M60/M62/M66 Simister Island Interchange

TR010064

7.16 APPLICANT'S RESPONSE TO ISH1 SUPPLEMENTARY AGENDA

Version	Date	Status of Version
P01	24 September 2024	Deadline 1

Reproduced by permission of Ordnance Survey on behalf of HMSO. © Crown copyright and database right 2024. All rights reserved. Ordnance Survey Licence number 100030649.

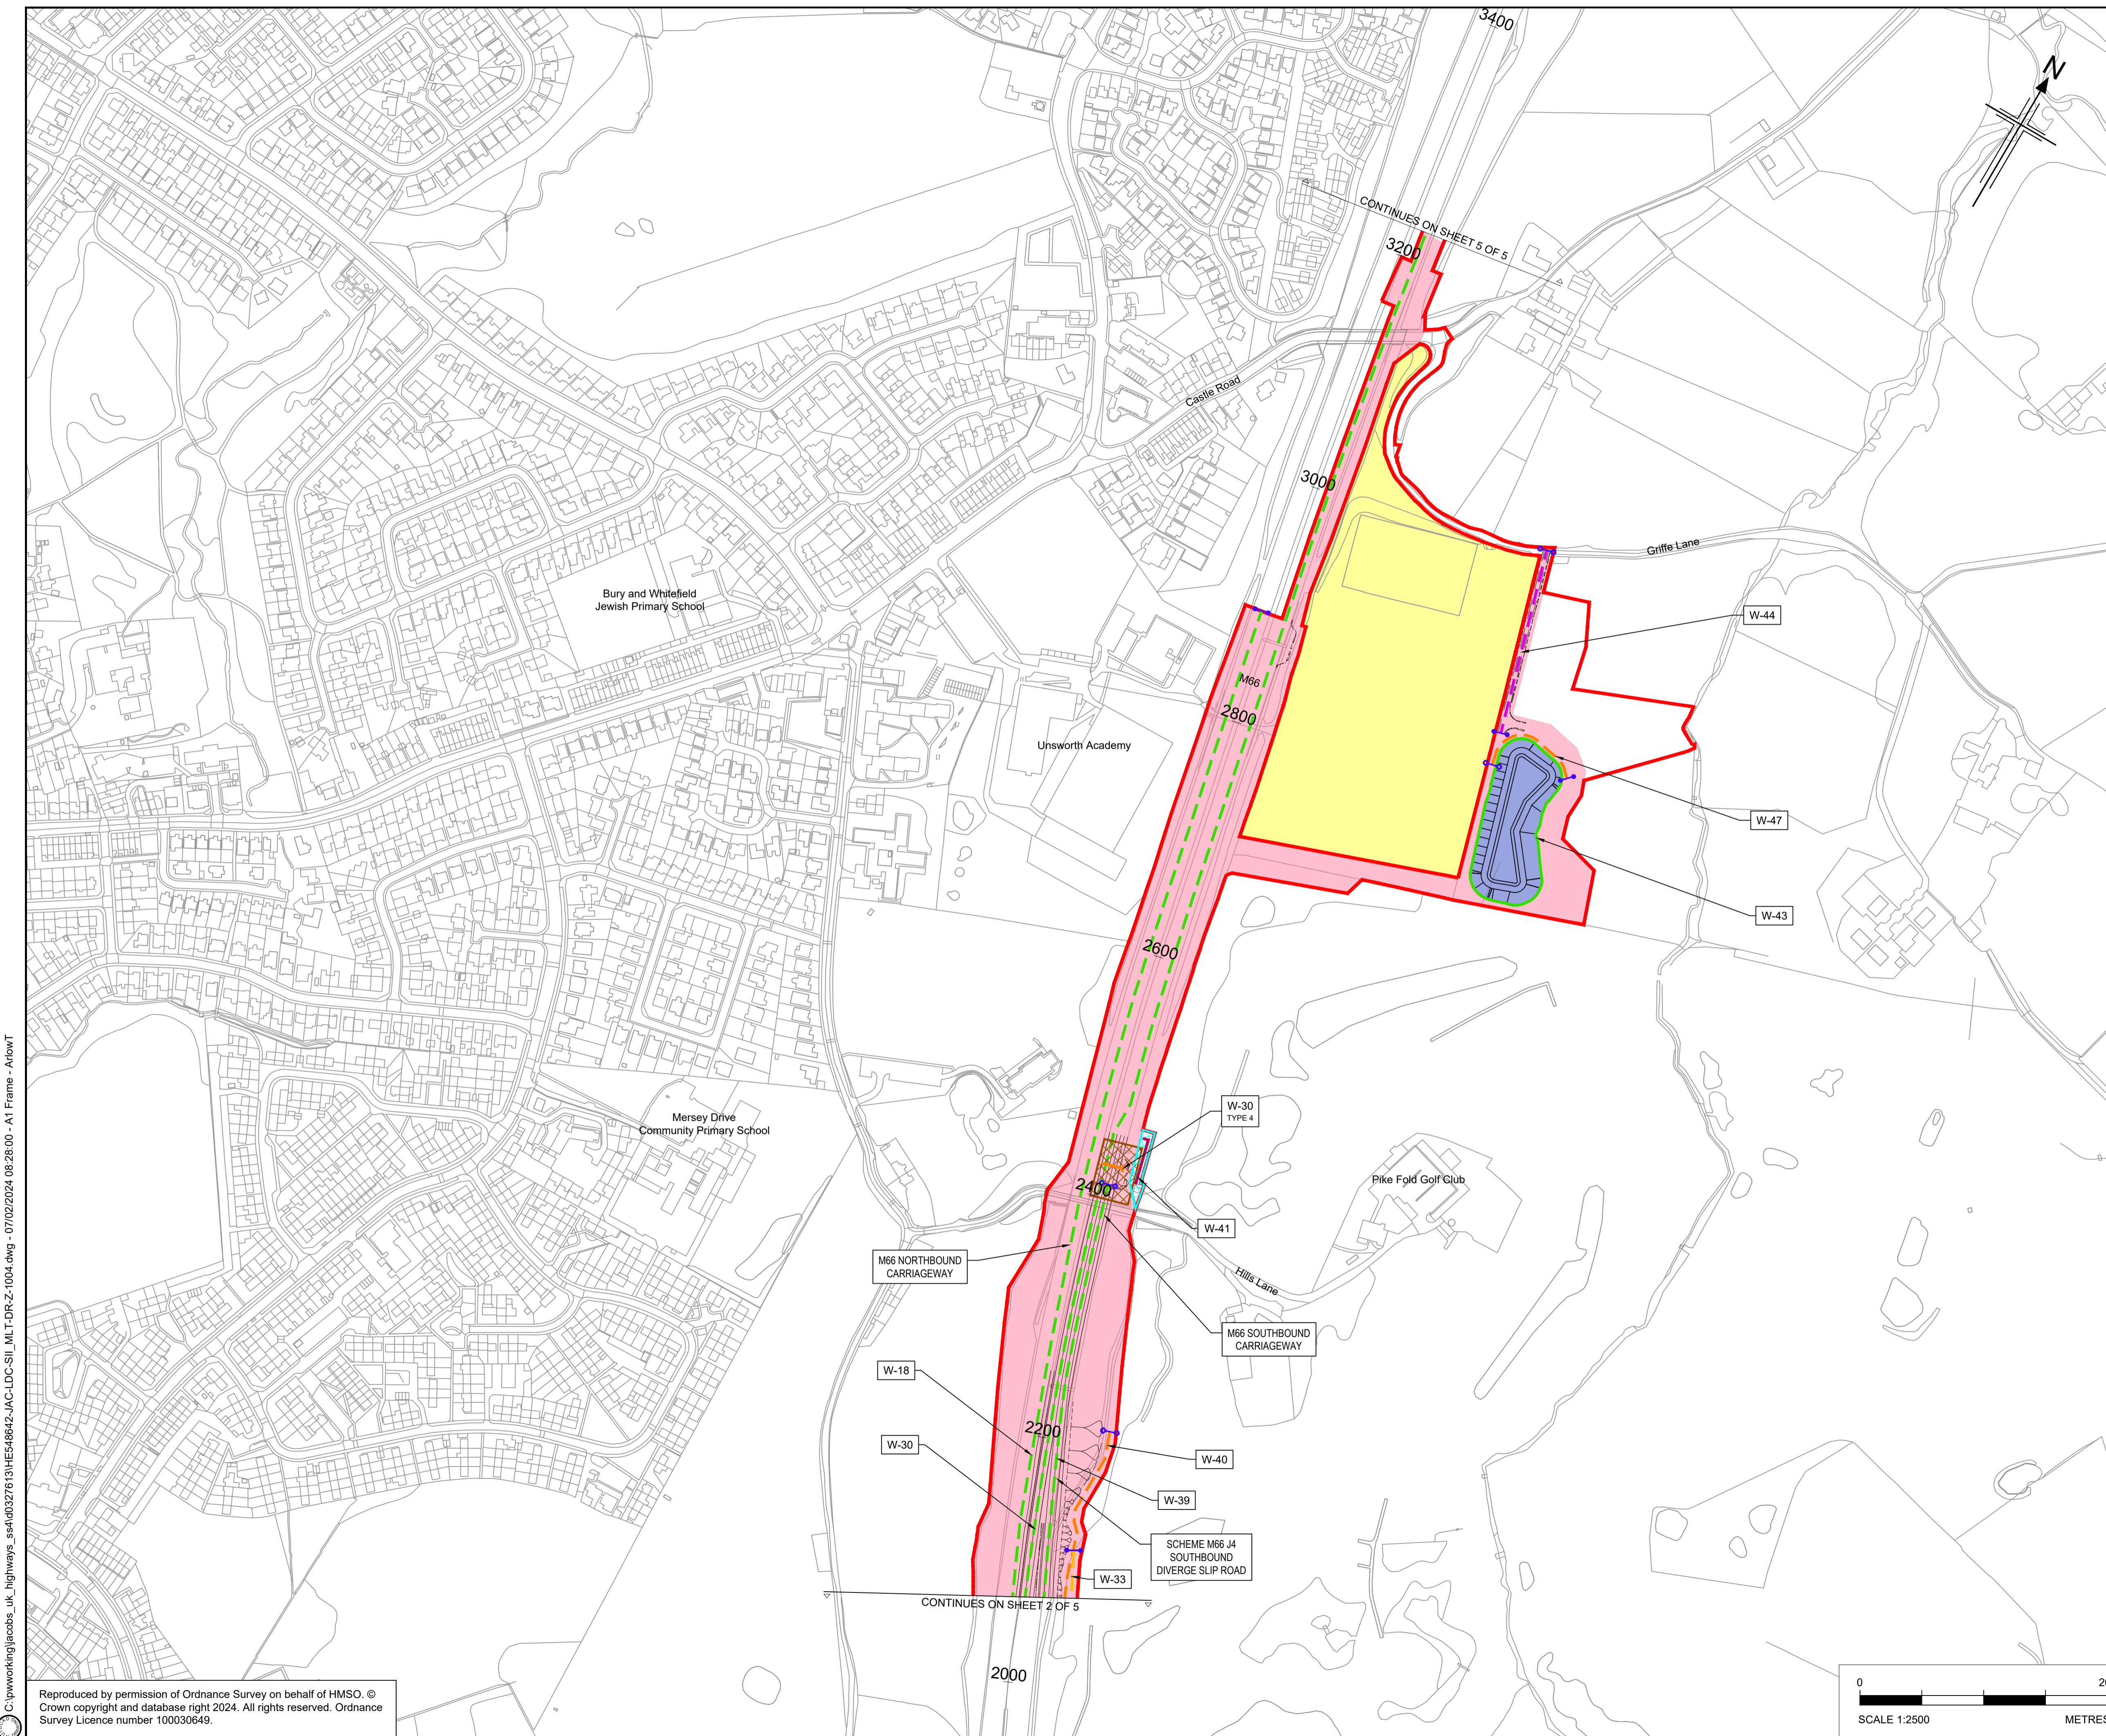
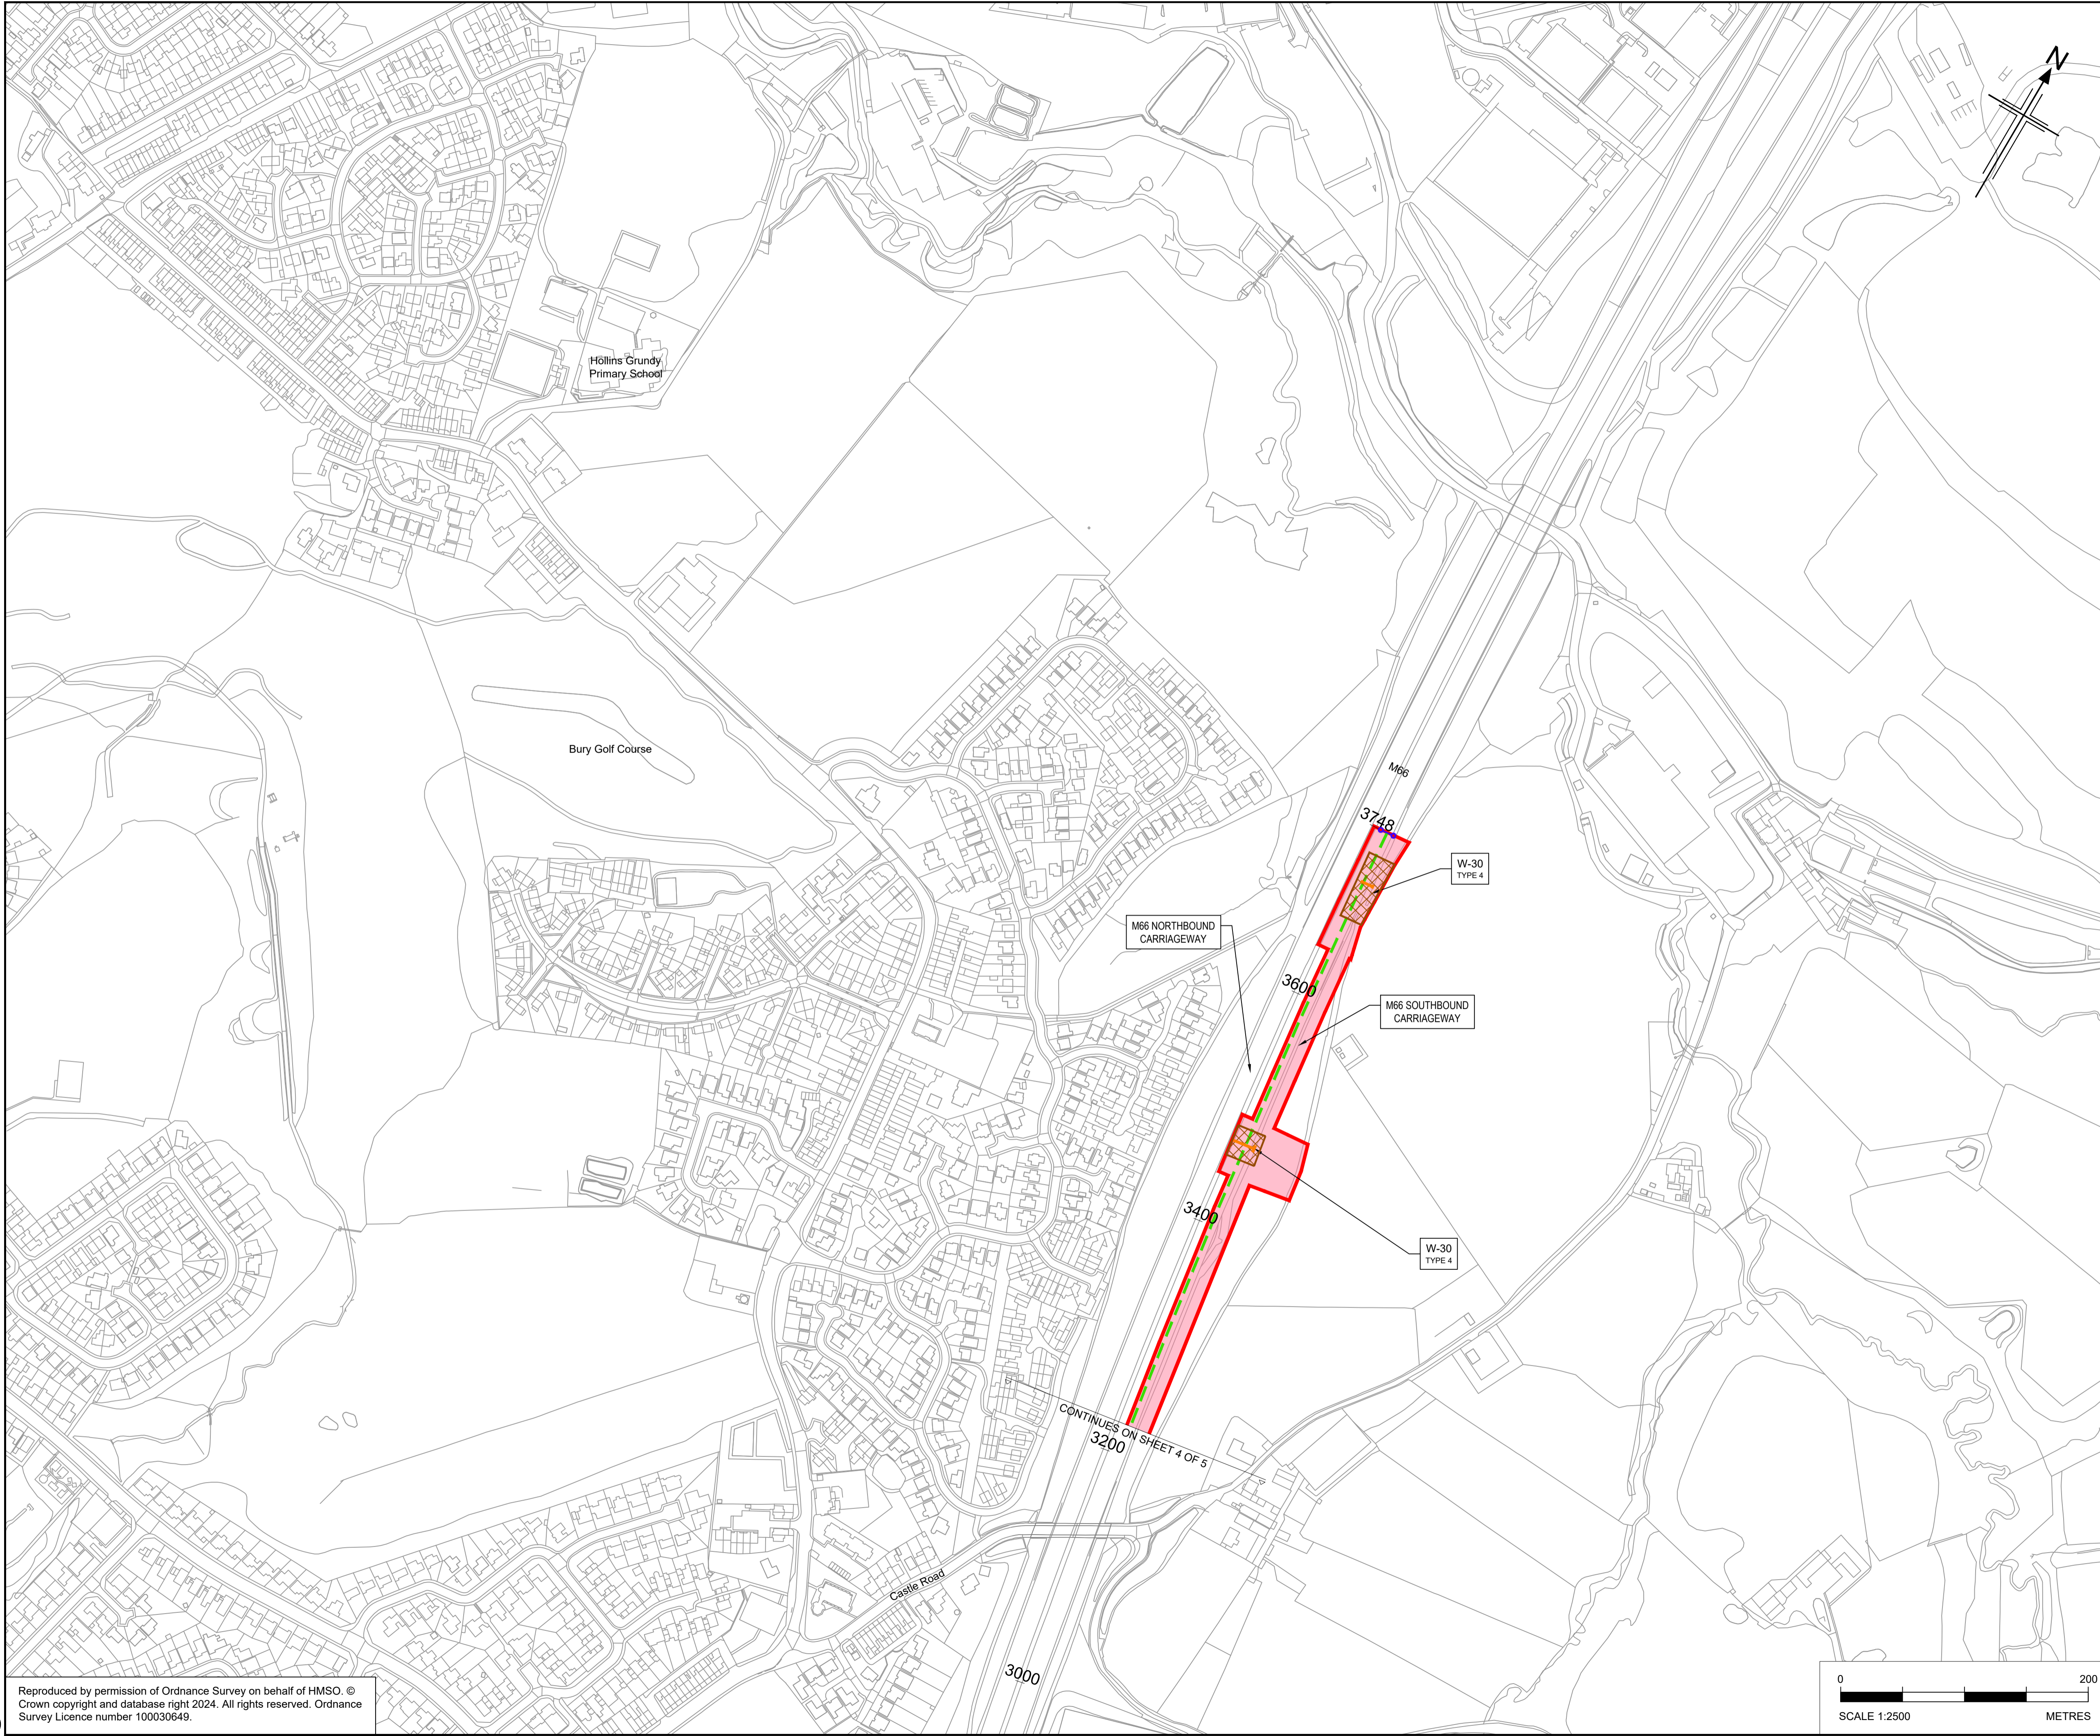
Part 2 – Principal Powers				
ISH1.A.13	Clarification	Applicant	Article 6(1)(a) – Limits of deviation The works plans [AS-006] referred to in paragraph (1)(a) identifies in the 'Key' to each of the plans limits of deviation applying to 'Highway Work', 'Scheme Gantry' and 'Utility Diversion'. Please clarify, what would 'Highway Works' include?	'Highway Works' includes all of the works comprising the authorised development except gantries and utilities. For instance, it would include carriageway, structures, environmental mitigation features (ponds etc.) and temporary works (haul routes etc.). The limits of deviation for gantries and utilities have their own limits of deviation because it is often requested and has become common practice.
